# Rezoning Transportation Analysis

Petition Number: 2020-074

General Location Identifier: Tax ID 05107104

Date	Description
07-22-20	First Review
08-26-20	Second Review

SHEET TITLE:
CONDITIONAL REZONING: CONCEPTUAL SITE PLAN
SHEET NUMBER:
RZ1.0

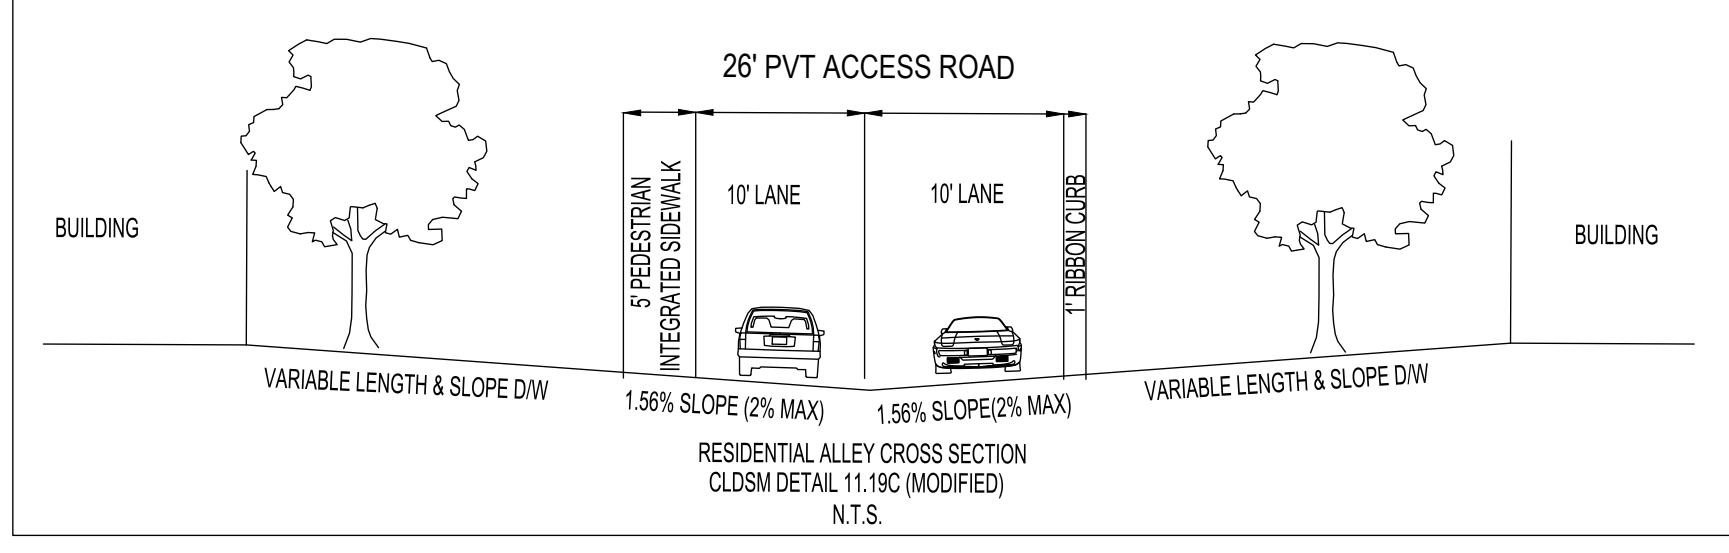
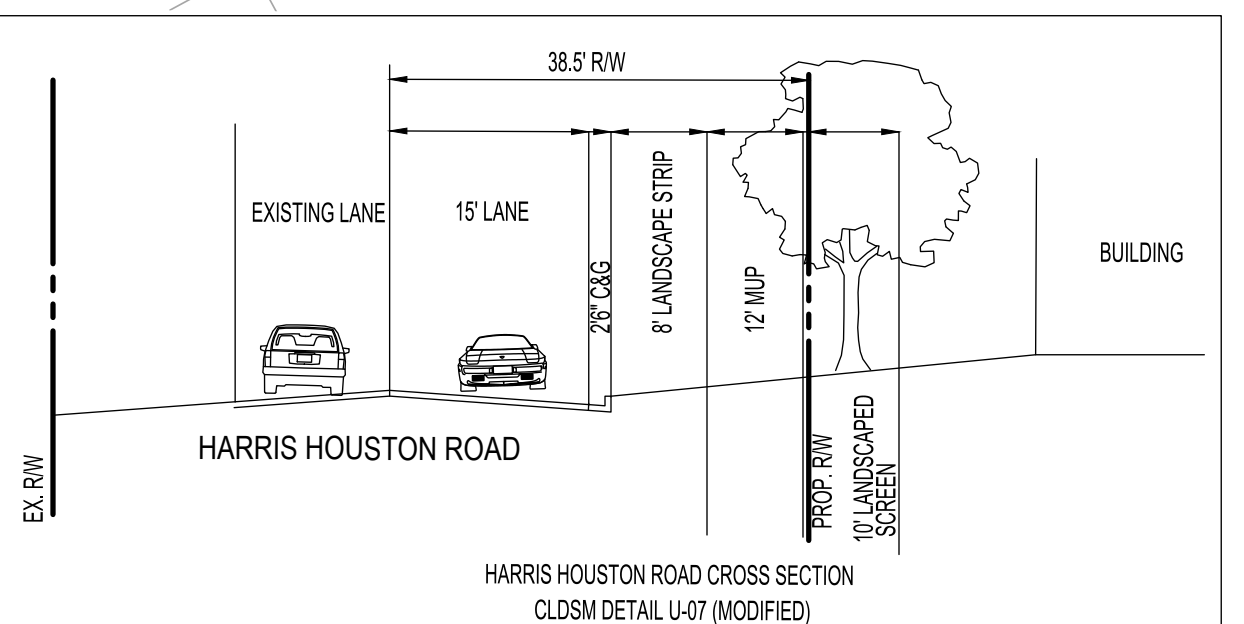
**Minor Outstanding (site plan dated 8-17-20)** Please add dimensions on the site plan. The site plan should show the curb and gutter labeled and dimensioned from the centerline for each road.

- Minor Outstanding (site plan dated 8-17-20)** Please include this language within the rezoning conditional notes. The petitioner should revise the site plan to add a note specifying dedication and fee simple conveyance of all rights of way to the City before the site's first building certificate of occupancy is issued. CDOT requests right of way set at 2' behind back of sidewalk where feasible.

- New Comment (site plan dated 8-17-20)** The petitioner should revise the site plan and conditional note(s) references to "12' asphalt MUP" to CLDSM standard detail number 10.42 – Multi-use Path.
